Oakdale West Industrial Estate Stage 3 (SSD 9794683) – Amended Development Application

This Amended Development Application (DA) Request has been prepared by *Keylan Consulting Pty Ltd* (Keylan) on behalf of *Goodman Property Services (Aust.) Pty Ltd* (the Applicant). The request is submitted for the Oakdale West Industrial Estate (OWE) Stage 3 State Significant Development (SSD) application (SSD 9794683), which was lodged on 10 February 2021

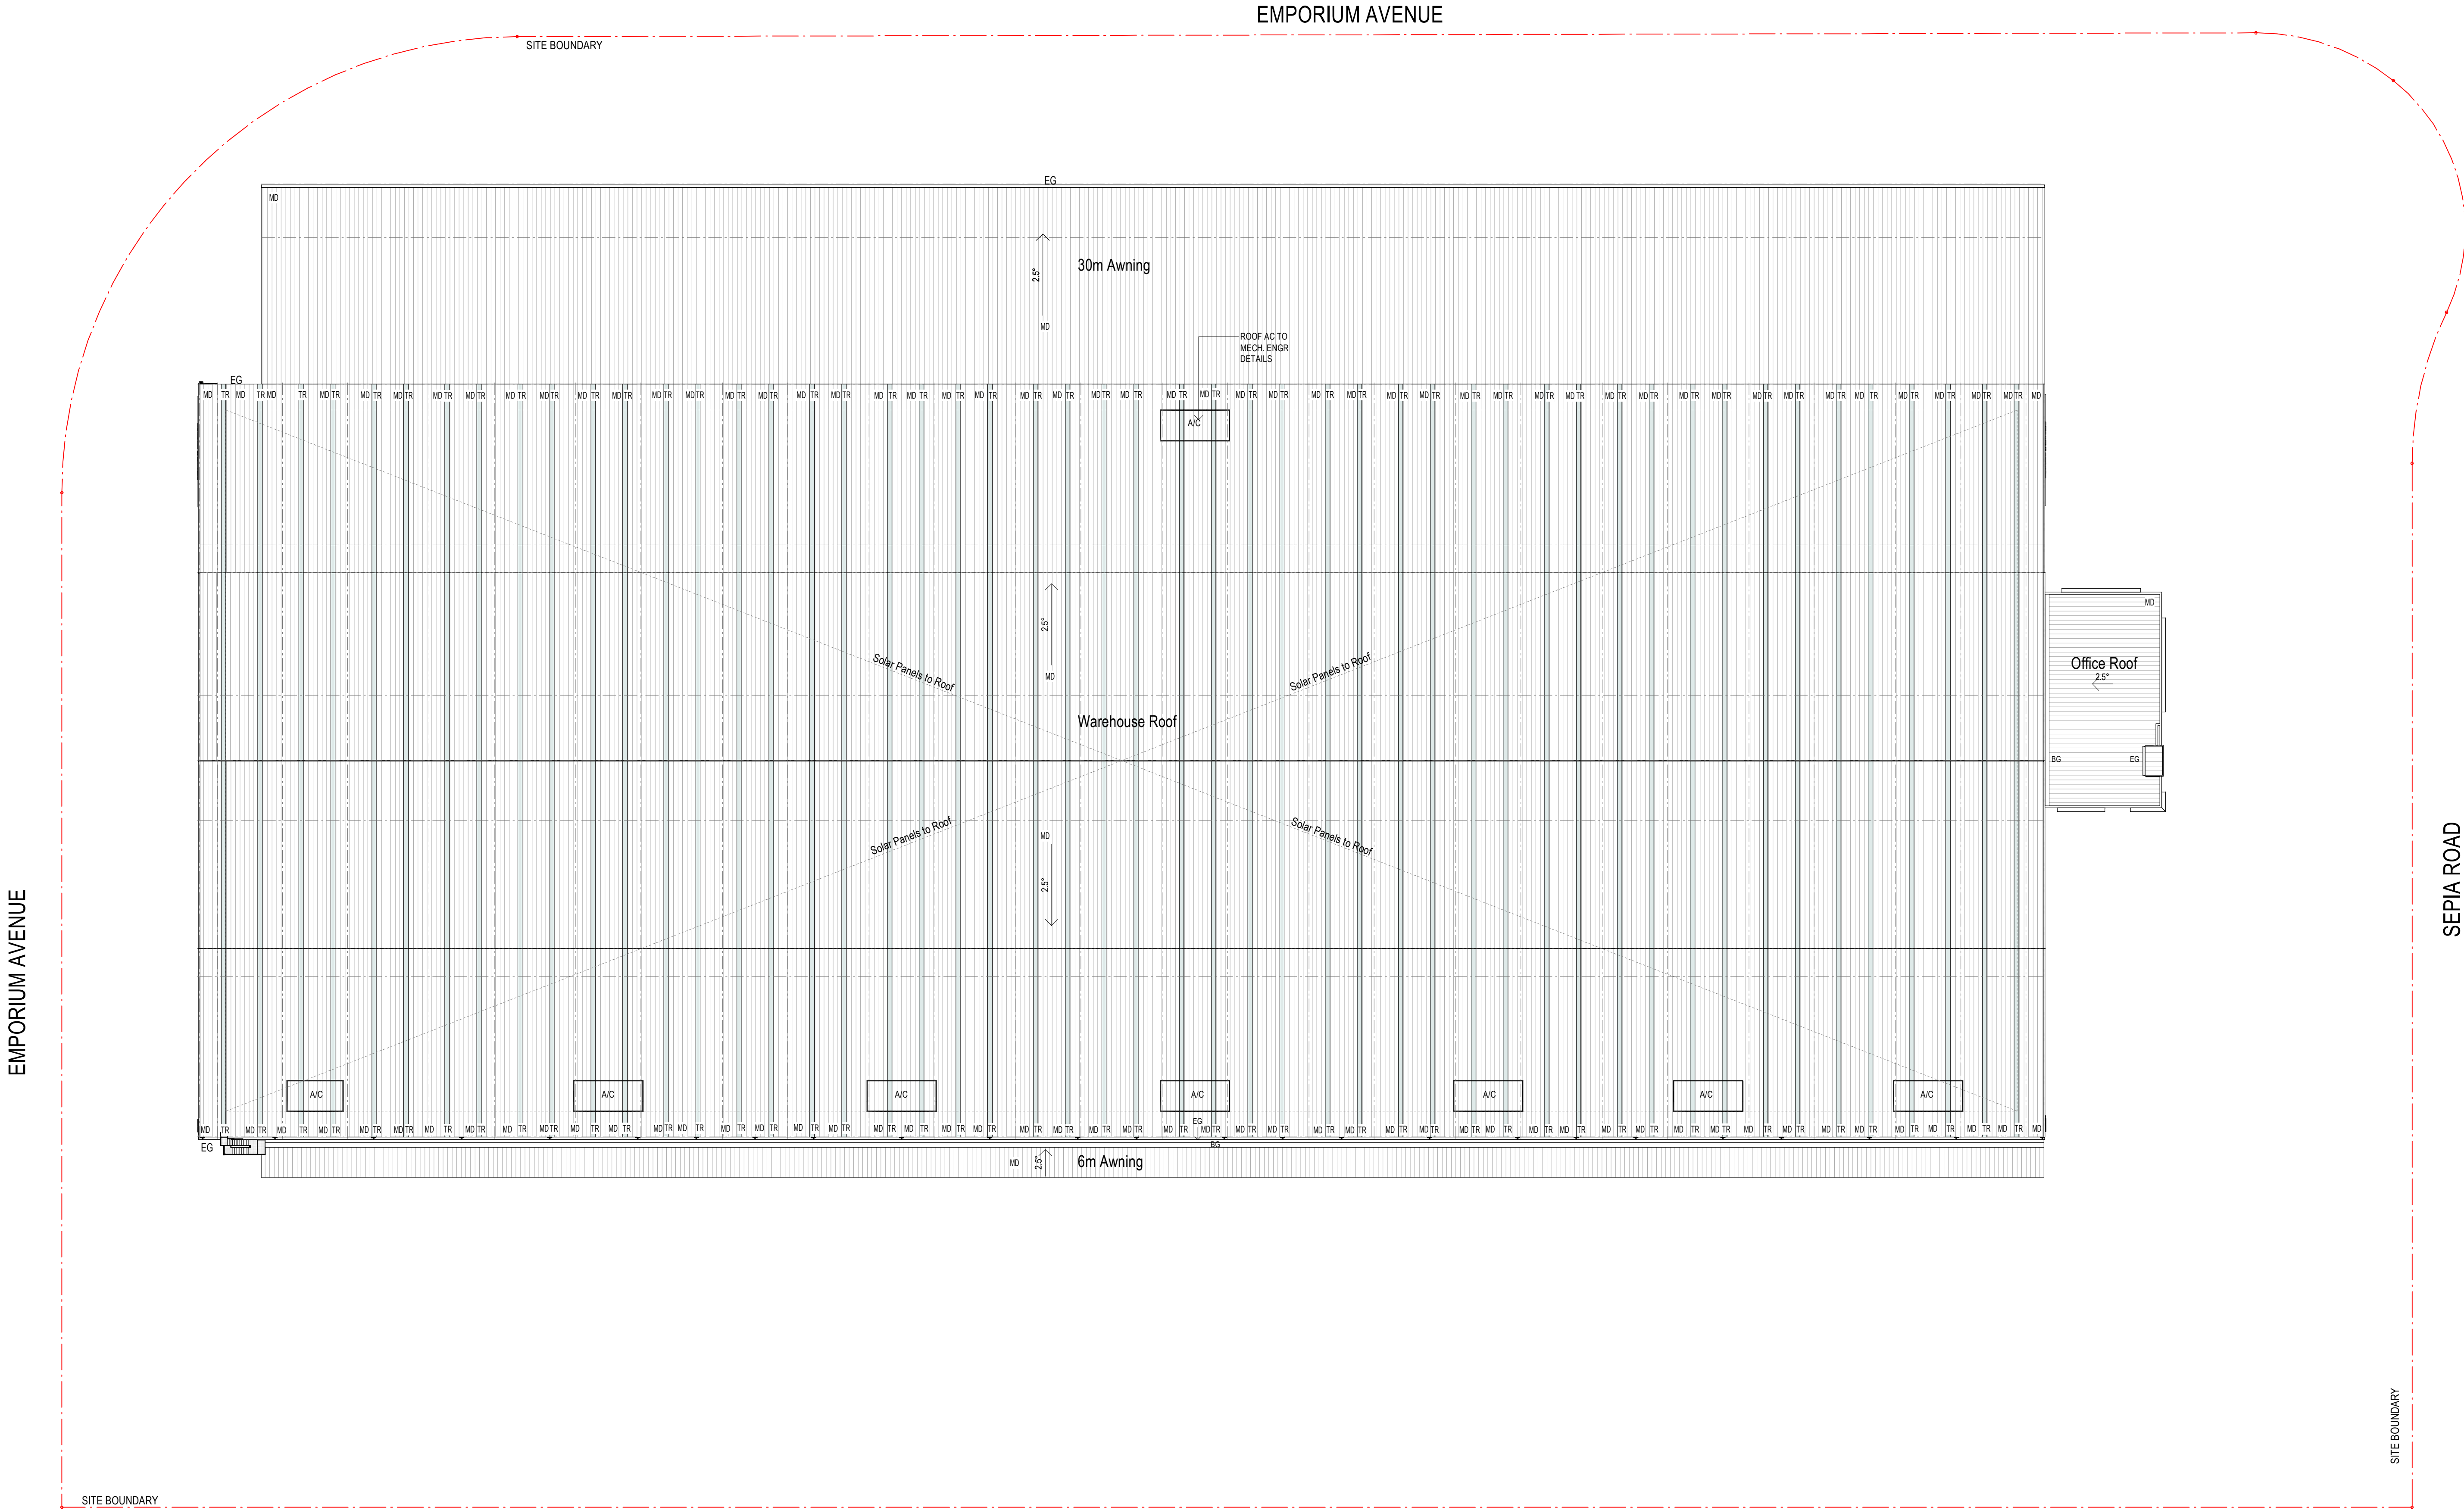
The Applicant has now secured a tenant for Building 2A and consequently requires changes to the warehouse building to reflect the tenant's operational requirements, resulting in refinements to the proposed layout and access.

The tenant for Building 2A intends to use the warehouse for parcel processing and distribution. The key proposed amendments to Building 2A include:

- 15% reduction in site coverage (from 58% to 43%)
- 9,738 square metre (m²) (22.1%) reduction in warehouse building footprint (from 44,000 m² to 34,262 m²) and additional 8,403 m² mezzanine

- 2,385 m² (5.1%) reduction in overall Gross Floor Area (GFA) (from 46,400 m² to 44,015 m²)
- 10,788 m² (23.3%) reduction in overall Gross Lettable Area (GLA) (from 46,400 m² to 35,612 m²)

- 1.2 m reduction in ridge height (from 14.9 m to 13.7 m)
- Changed access for car and truck entry/exit points
- Peak traffic generation occurring outside the estate network peak periods of 7 am to 8 am and 5 pm to 6 pm, changing to 5 am to 7 am and 9 pm to 11 pm

- 44 additional car parking spaces (from 208 to 252 spaces) and repositioning of the carpark to the eastern side of the site
- Use of temperature control at the southern dock with units placed on the warehouse roof

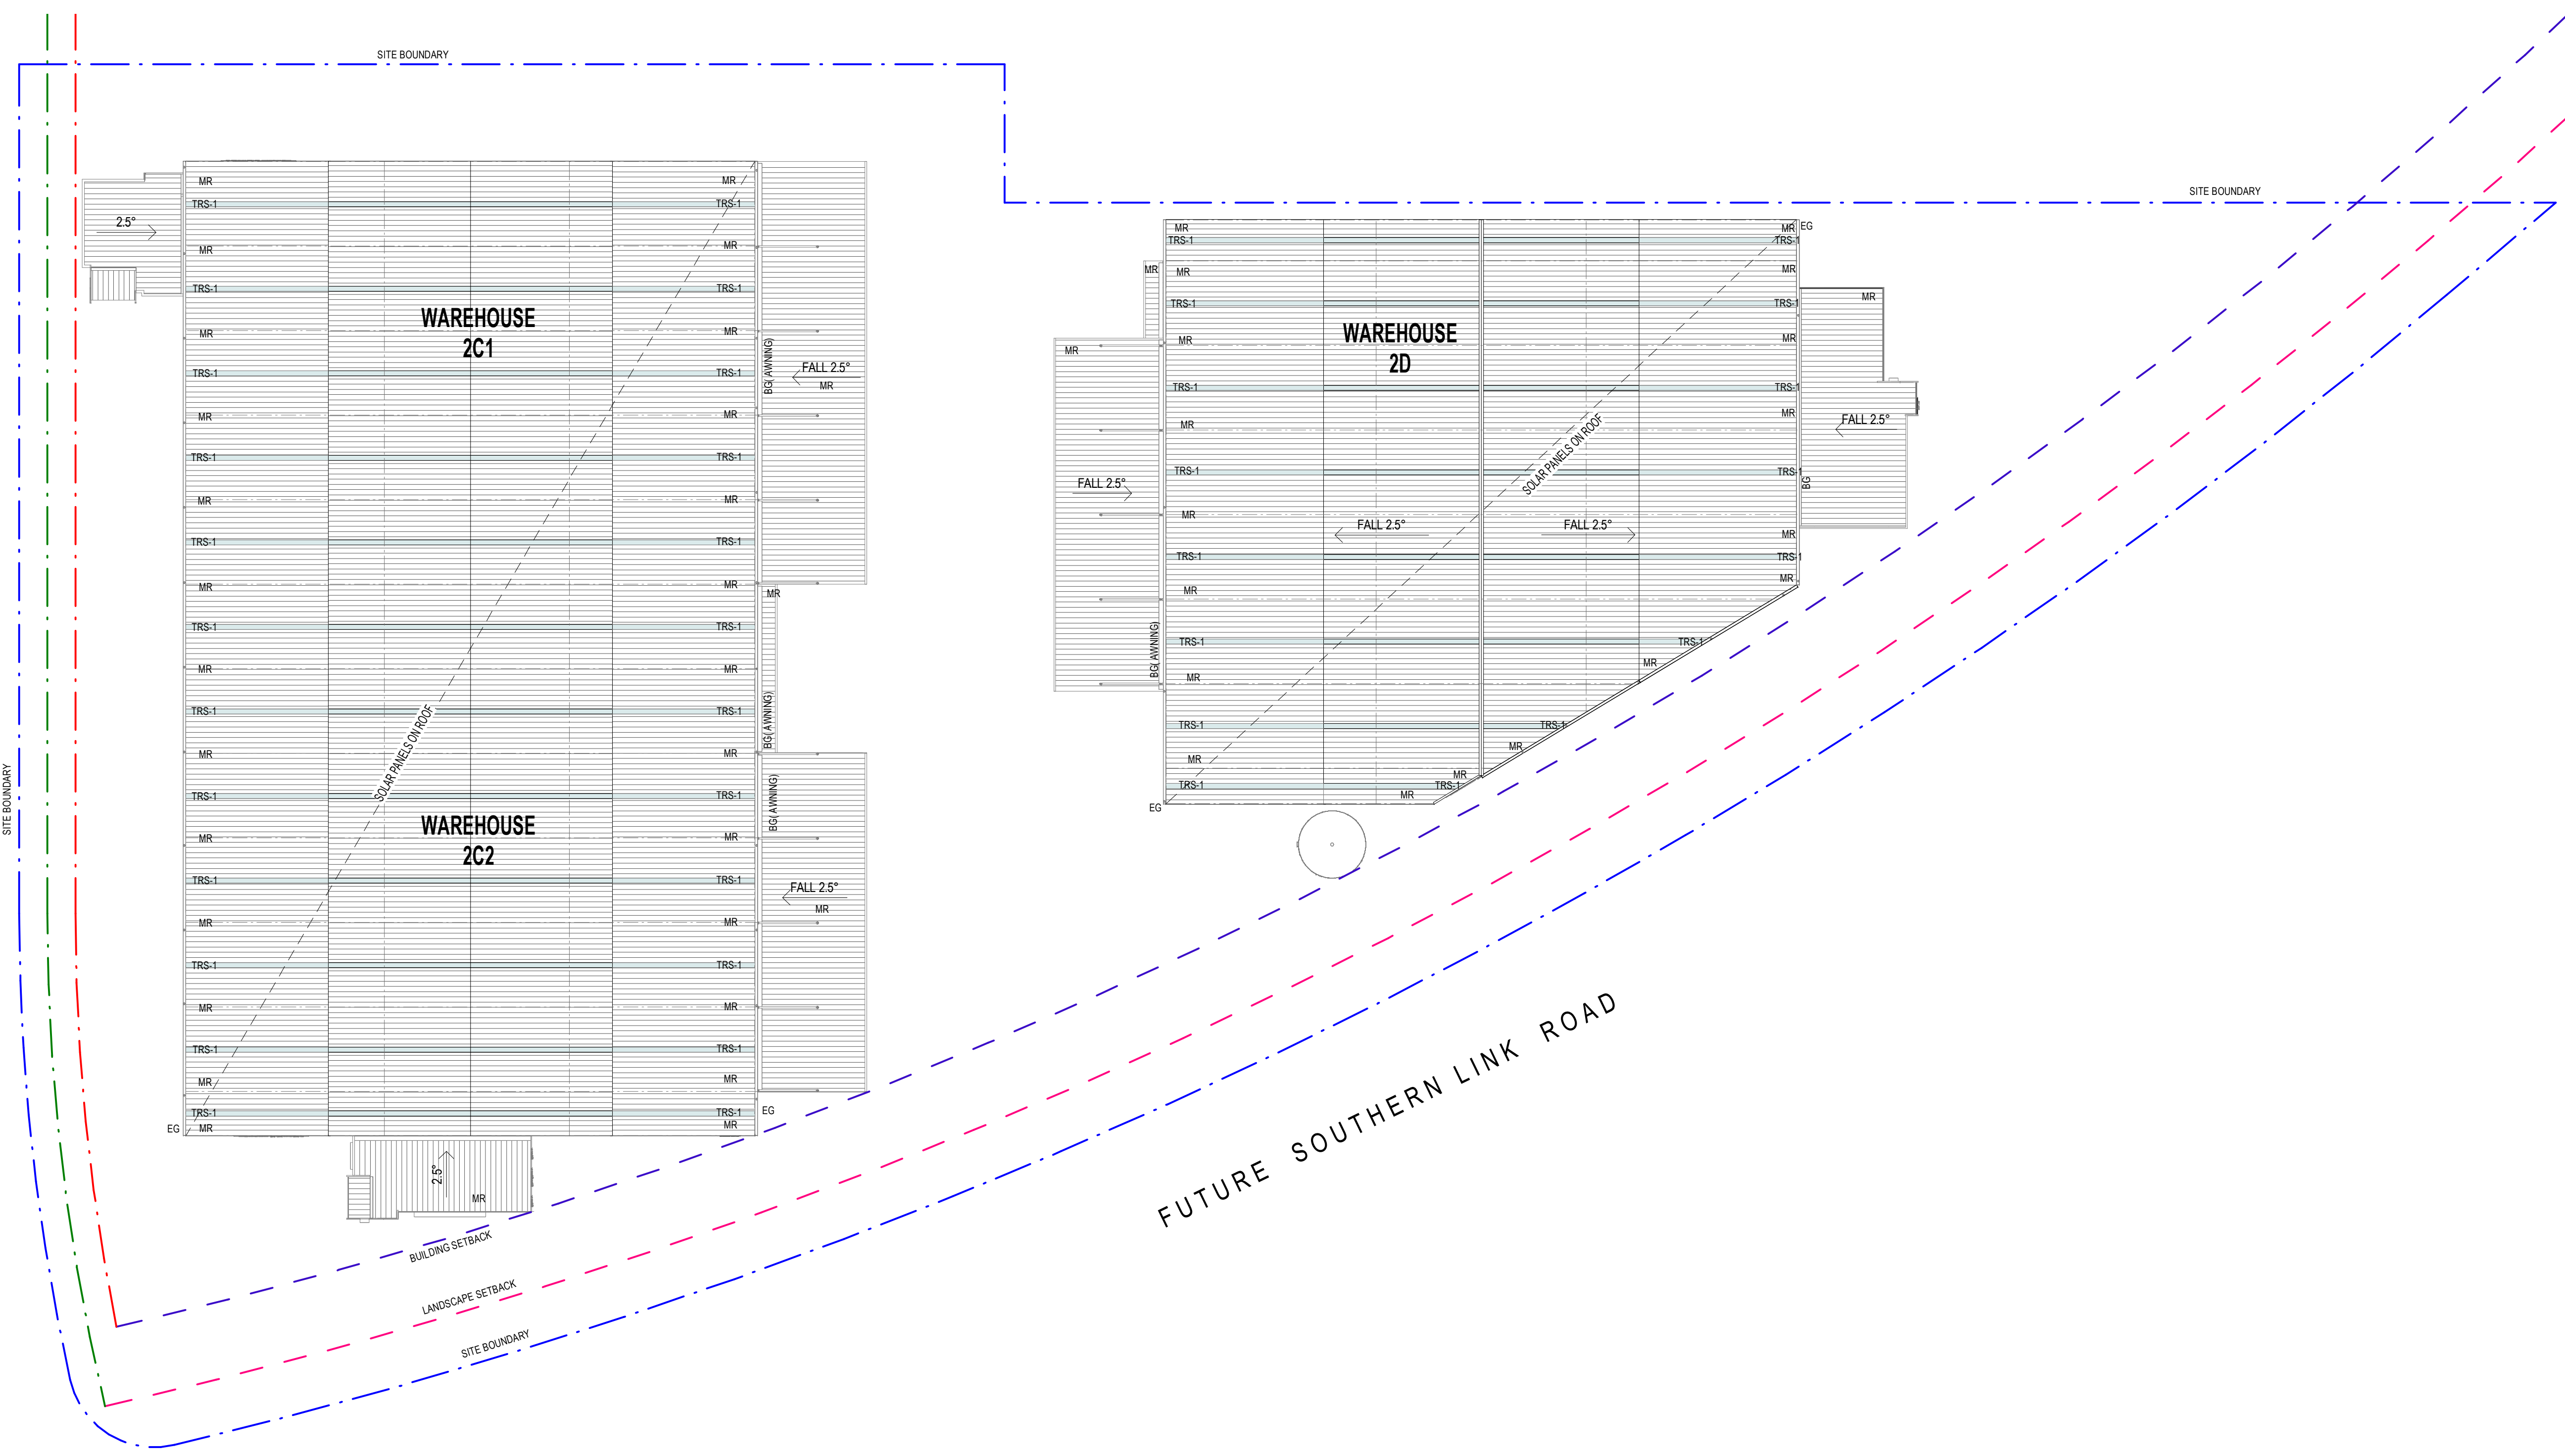
The Department notes that a shared light and heavy vehicle driveway is proposed for access to the Building 2D car park. The Department agrees with Council that this has potential traffic safety impacts along the driveway and within the loading dock area. It is requested that an alternative access arrangement be provided for light vehicles to the car park, noting that landscape setbacks along each boundary must be maintained.

Figure 3 shows the originally proposed site and warehouse plan, with shared access for heavy vehicles and light vehicles accessing the carpark for Building 2D. Figure 4 shows the revised scheme whereby access to Building 2D car parking is provided via the same driveway which accesses parking for Building 2C.

The amended access to car parking for Building 2D reduces any potential for conflicts between truck and car movements. The revised access requires the provision of an access driveway and parking along the southern boundary of the lot. The access driveway does not encroach into any required setbacks, including landscaped.

The Applicant has considered the Department's comments and has amended the proposed access and parking arrangements for Building 2D.

The proposed amendments include a 2% increased overall site coverage (from 43% to 45%) with 3 additional car parking spaces (from 50 to 61 spaces) at Buildings 2C1 and 2C2. The proposed amendments to Building 2D include:

- an 855 m² (17%) increase in building footprint (from 5,005 m² to 5,860 m²) and corresponding 855 m² (16%) increase in overall GFA/GLA (from 5,380 m² to 6,235 m²)
- one additional car parking space (from 55 to 56 spaces)
